Q1.7.1 General - review of deadline 1 documents: Review the updates to the application documents (see table 1 of the applicant's cover letter [REP1-001] for an overview of the updated documents) and the additional documents (see table 2 of the applicant's cover letter) submitted at deadline 1, the applicant's responses to the relevant representations [PDA-006] and confirm whether the comments or amendments have addressed your concerns regarding the impacts on biodiversity and ecology (as applicable). If the changes have not sufficiently addressed your concerns, set out how the documents could be further updated to overcome them.

Q1.7.10 Surveys of Bechstein's bats: Provide a view on Natural England's position regarding the survey work for Bechstein's bats [RR-203, AS-038, REP1-124] – to what extent do you agree or disagree with this and why?

Q1.7.19 Mitigation - woodland buffer distance: In your relevant representation [RR-020] and written representation [REP1-125] you suggest that a minimum buffer distance of 50 metres is required to designated woodland. Whilst noting the study referred to in your relevant representation, this does not represent guidance or a legislative require

Drawing number	Revision number	Drawing title	Scale
2.1	01	Environmental Considerations	1:25,000 @ A3
2.2	01	Existing Public Rights of Way	1:30,000 @ A3
2.3	01	Topography Plan	1:30,000 @ A3
2.4	01	Field Numbering System	1:30,000 @ A3

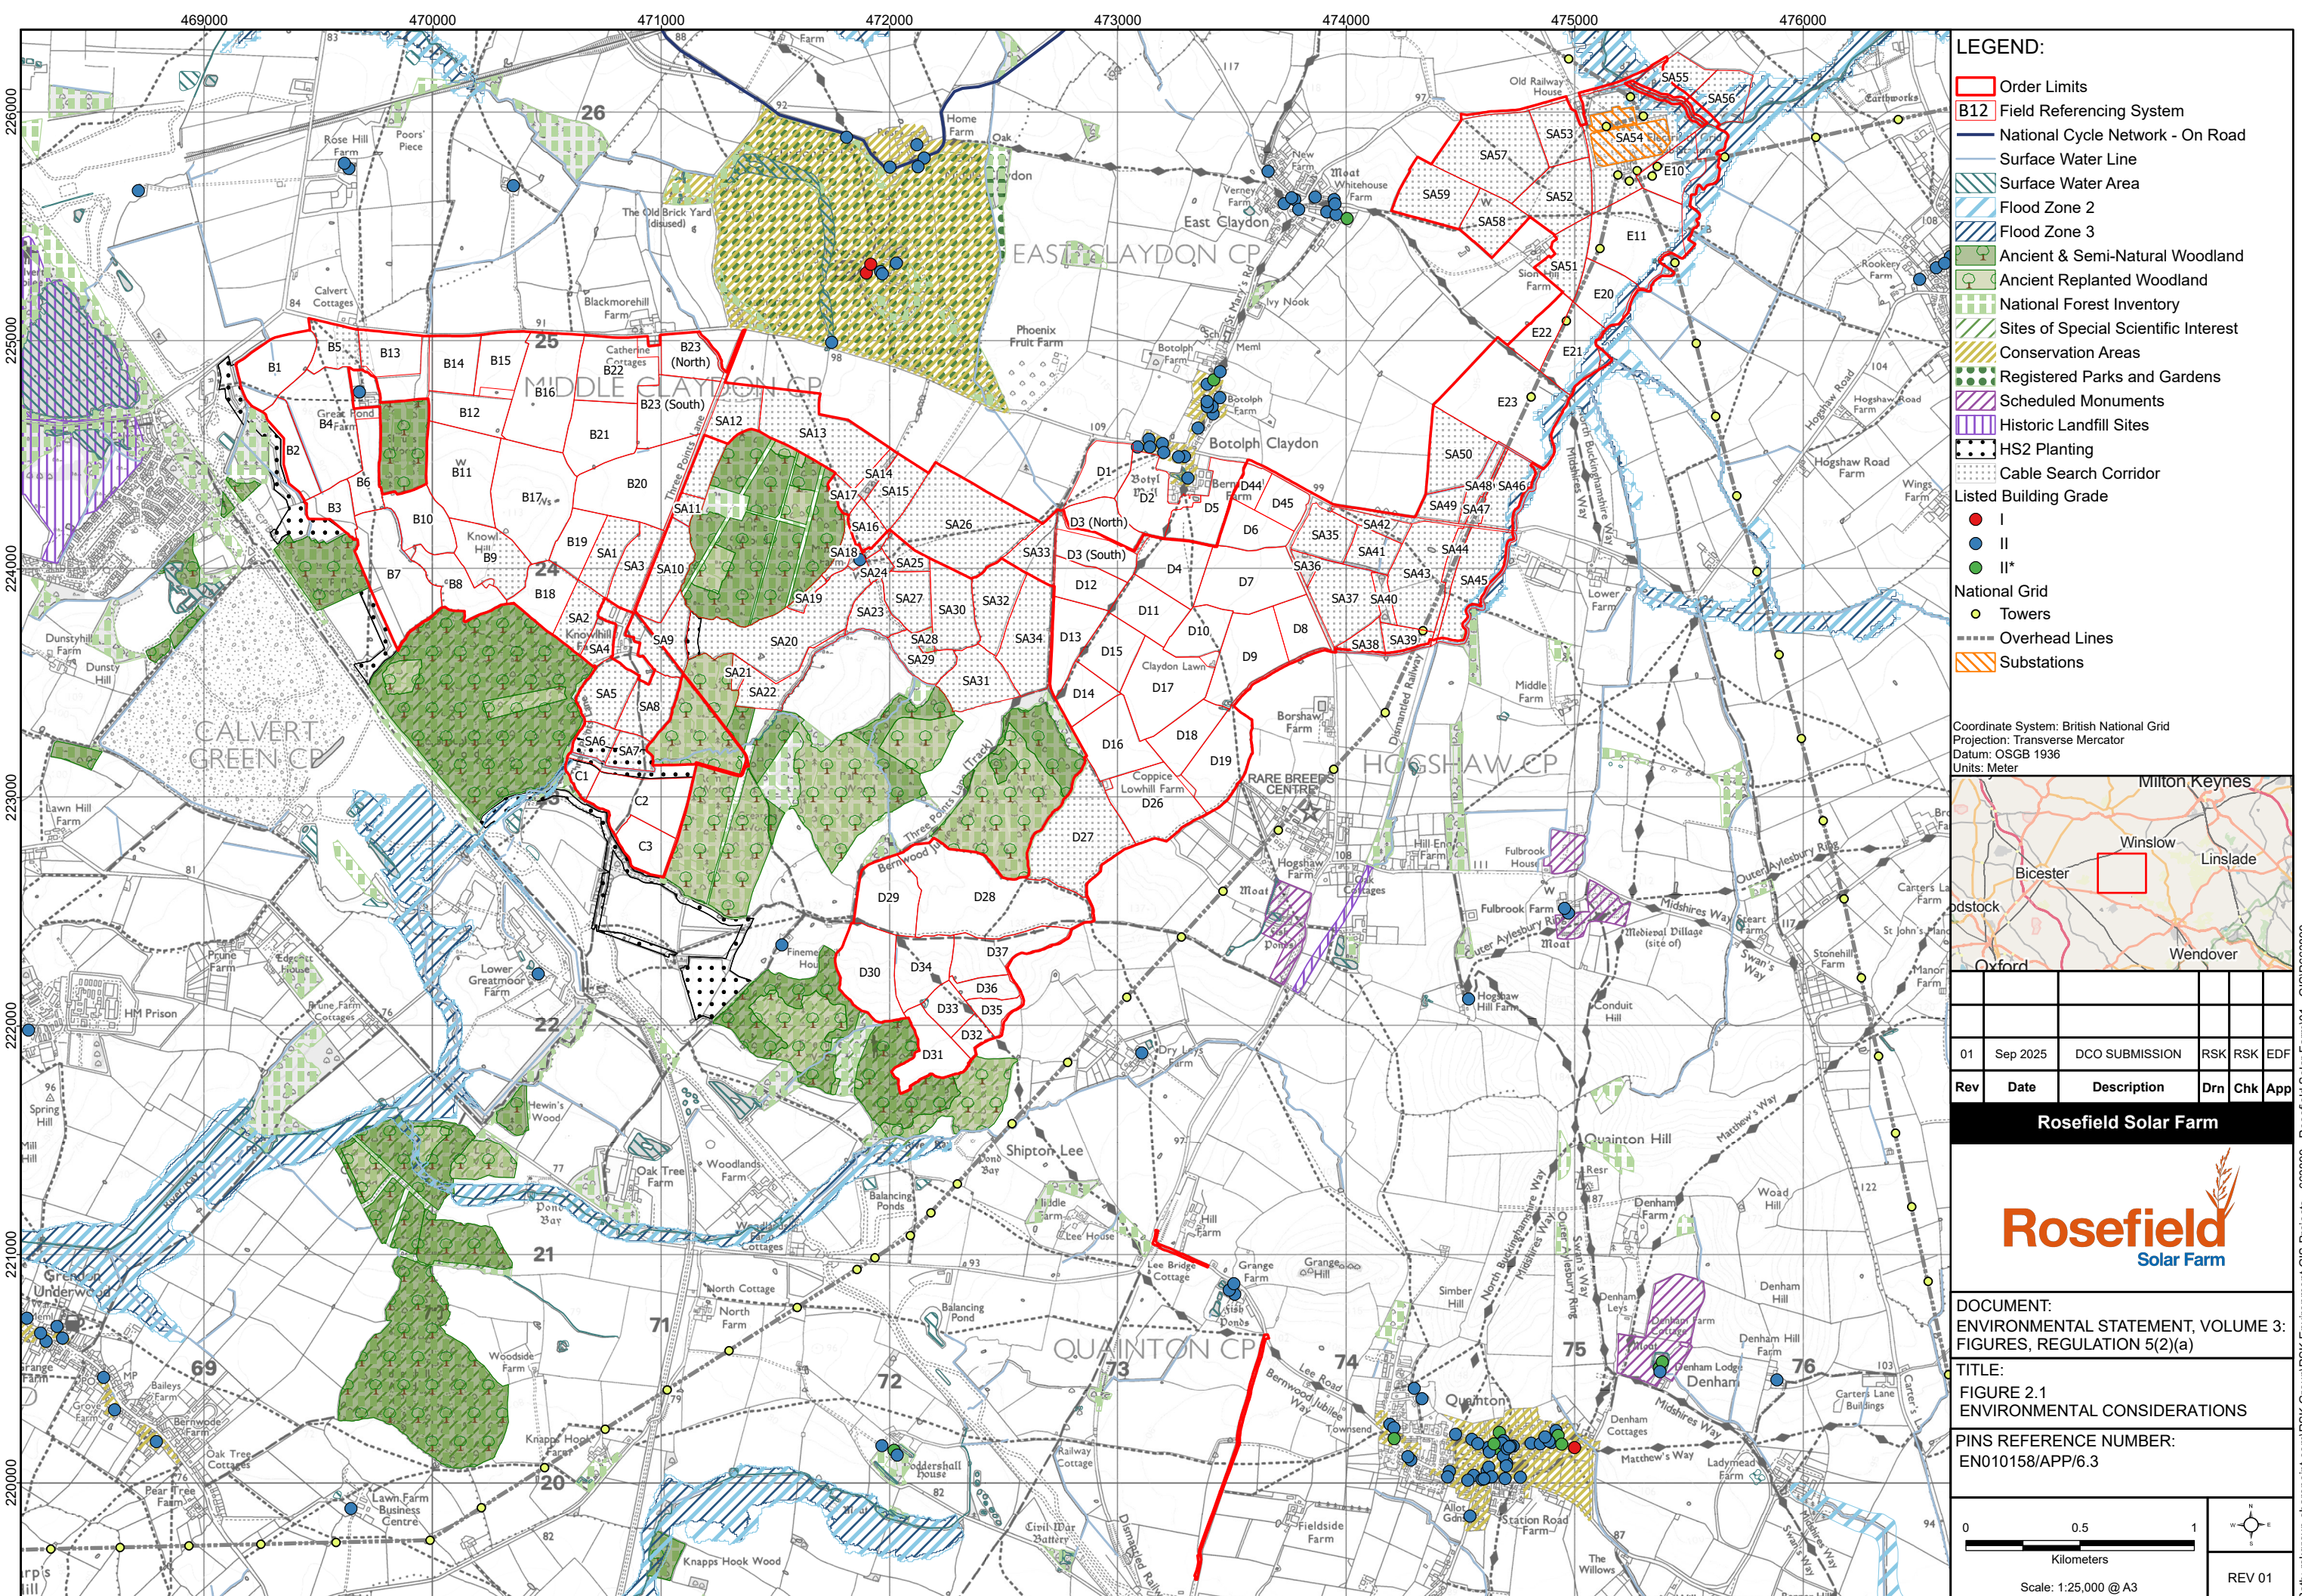
In line with NE's recommendation, BBOWT strongly agrees that as fields B6, B7 and B8 are identified as part of the core sustenance zone and a key area of the home range for the Bernwood Bechstein's bats, panel allocations should be removed and that this area should continue to be managed as cattle-grazed pasture with enhancements incorporated to buffer zones.
